**Consultation Response from KC,
Lead Local Flood Authority**

2025/93088 Wappy Springs Inn, Lindley Moor Road, Lindley Moor, Huddersfield, HD3 3TD

Discharge of details reserved by conditions 5 (C(E)MP), 6 (CEMP), 7 (surface water drainage), 8 (temp drainage), 9 (oil interceptor) on previous permission 2024/92553 for erection of mixed industrial development (Use Classes E(g)(ii, iii), B2 and B8); including demolition of existing structures, new yard, parking, landscaping, drainage features and ancillary structures

Date Responded: 1st March 2026

DUDLEYS CONSULTING ENGINEERS
 PROJECT: **WAPPY SPRINGS HUDDERSFIELDS**
 TITLE: **DRAINAGE STRATEGY SHEET 2 OF 2**
 SCALE: **1:125** PAPER: **A0** STAGE: **PRELIMINARY** STATUS: **REV.**
 DRAWING NO. **20392-DCE-XX-XX-D-C-101** REV. **PO3**

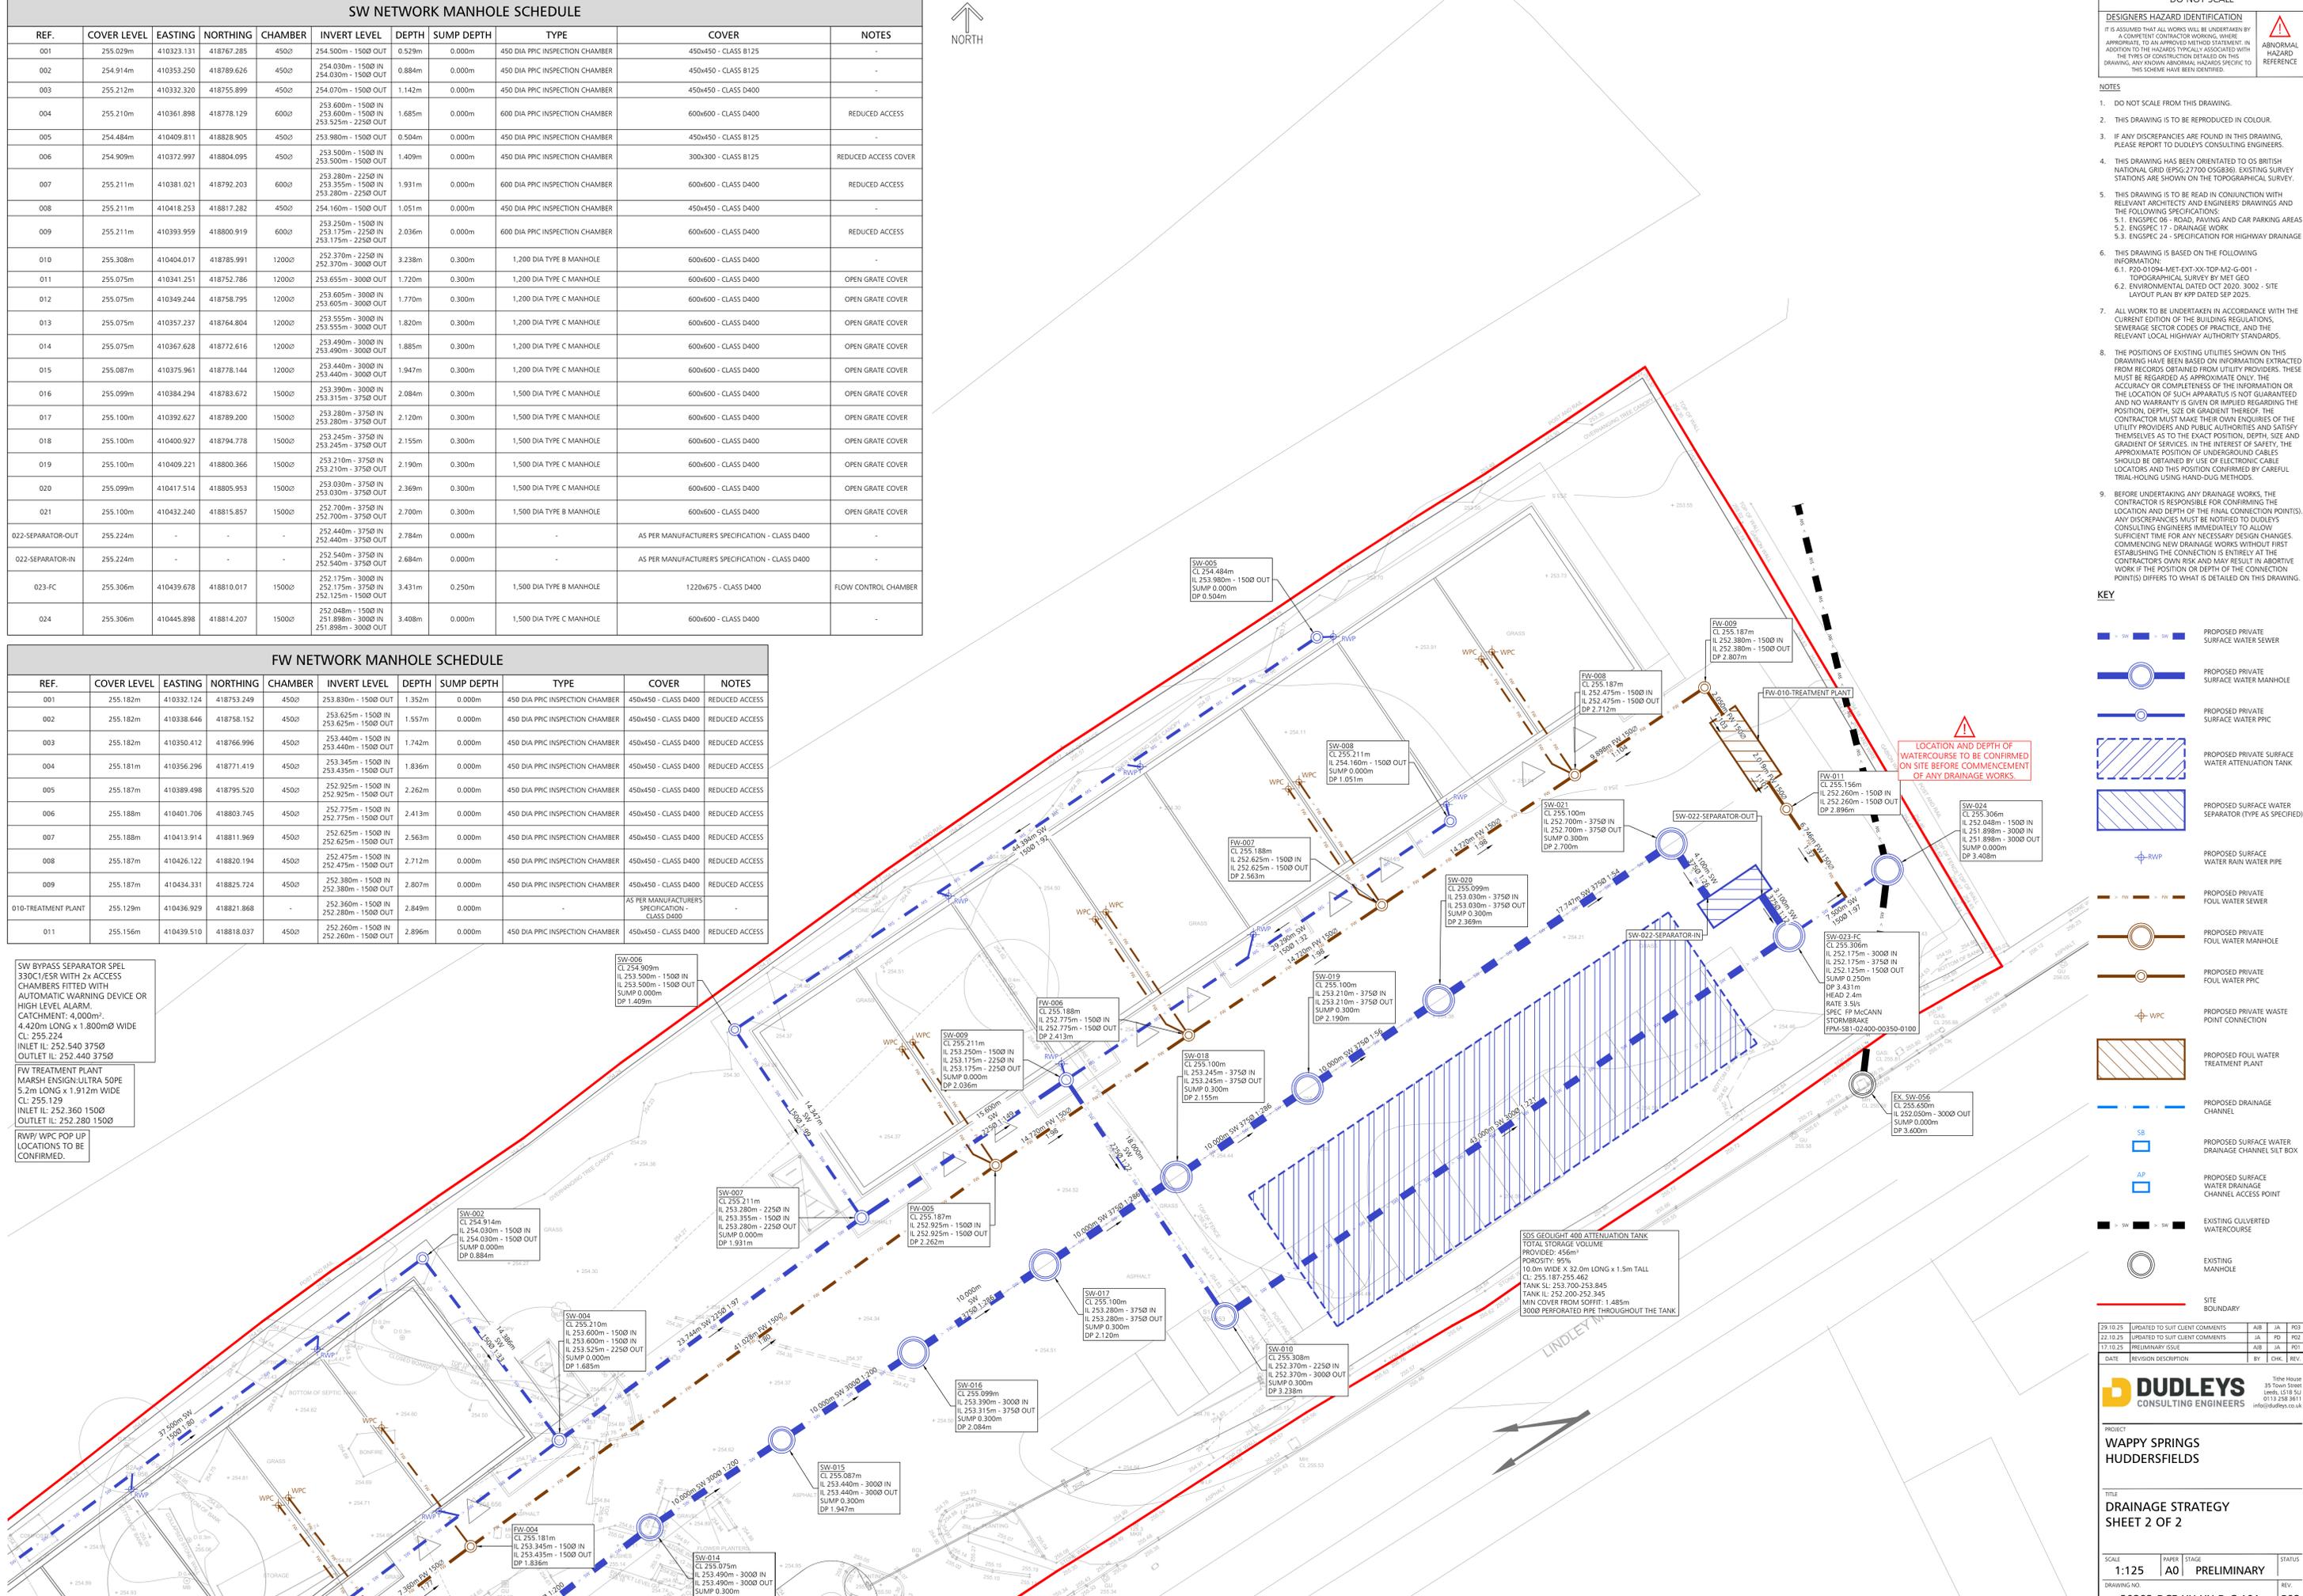
Plans and cross sections of the tank in line with our previous comments below have not been provided, along with improved bespoke maintenance and management plans. For more information please contact Flood Management at floodmanagement@kirklees.gov.uk

Full details of the tank, including plan and cross section, especially noting any drainage channels and access features for inspection and silt prevention are required. Unless a guarantee over longevity is stated or an independent assessment such as a BBA certificate, Kirklees would look to a conservative approach to replacing the crate storage that cannot be effectively cctv'd for periodic structural assessments. This would be a replacement every 25 years. The methodology on inspections and routine maintenance must be bespoke to the site and the selected style of storage. We believe some of the generic tasks listed might not be possible to carry out effectively.

This condition CANNOT be discharged at this moment in time.

An interceptor is shown on drainage plans, and a manufacturers brochure has been included in the submission. The plan should show the selected interceptor to demonstrate flow rates have been considered in sizing the specific model.

Further information is required prior to discharging this condition.

DRAWING NO. **20392-DCE-XX-XX-D-C-101** REV. **P04**

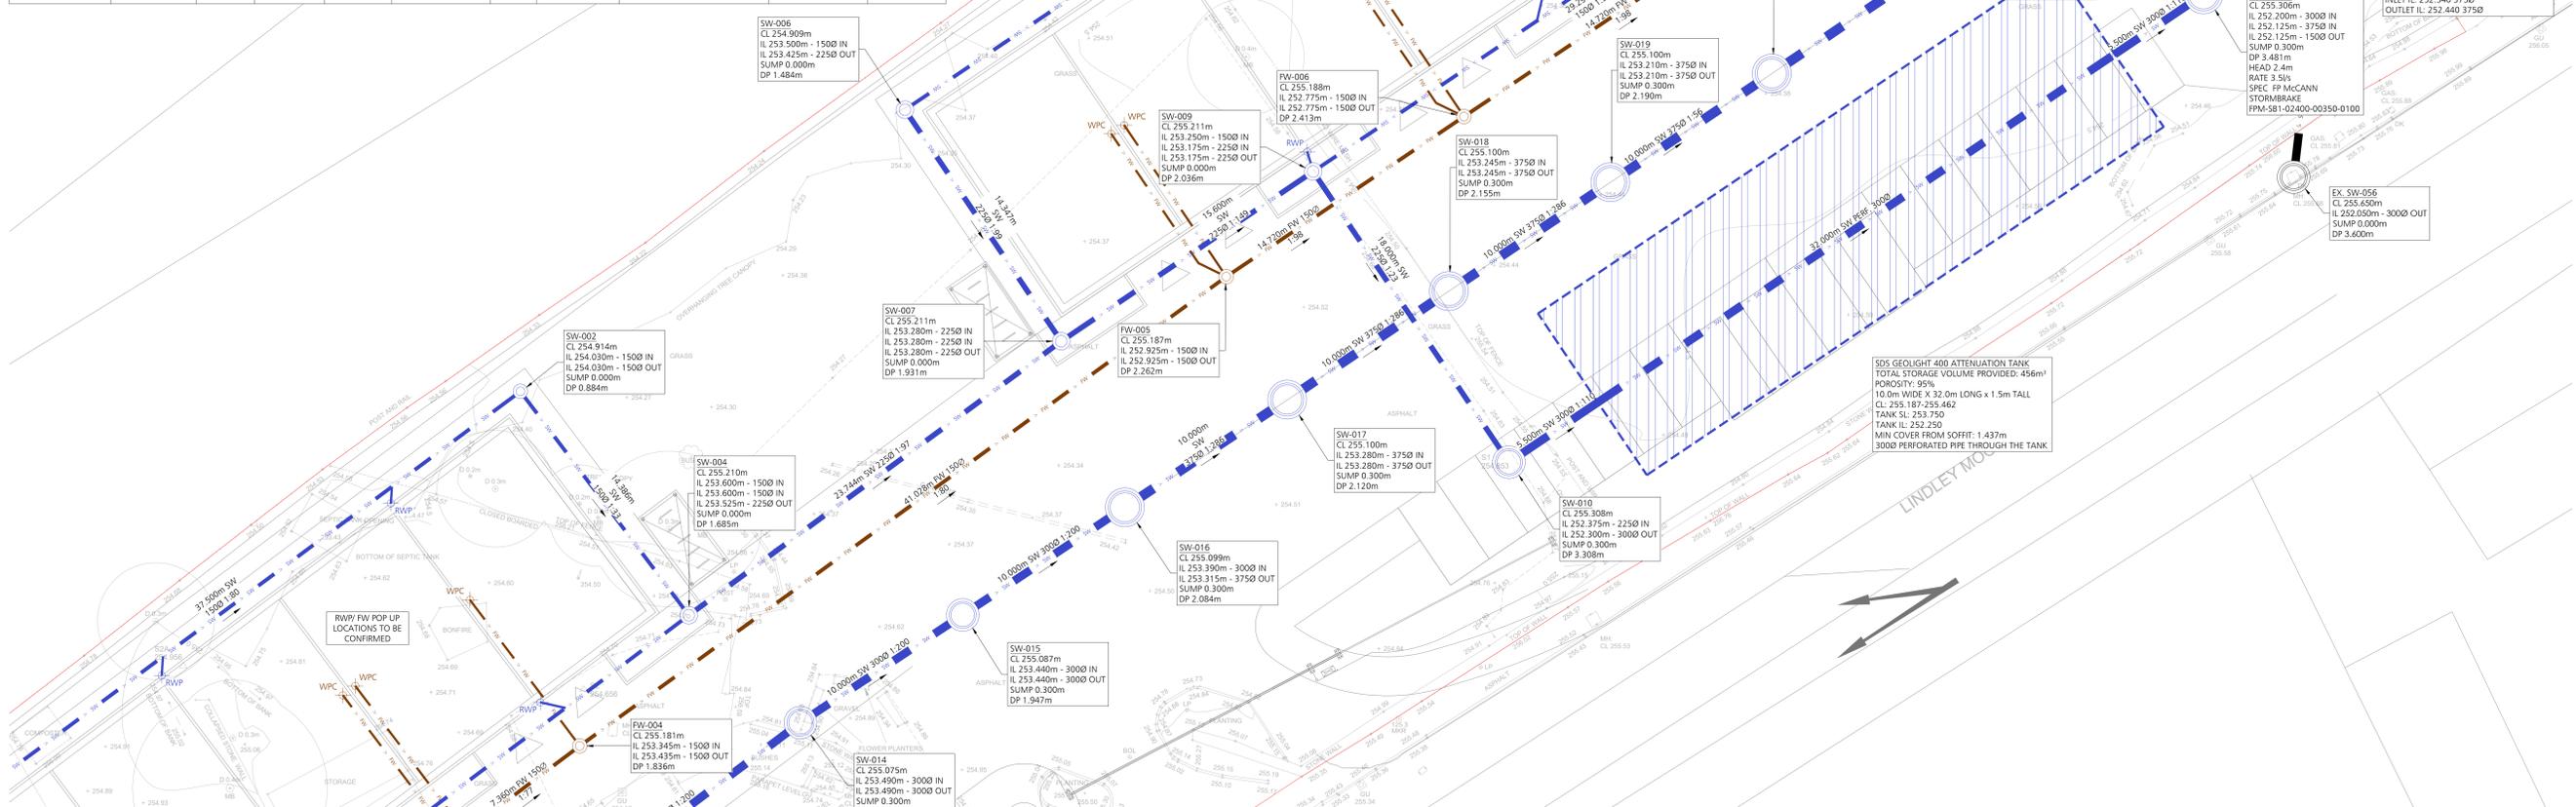
No additional material has been supplied. Our previous comments still stand.
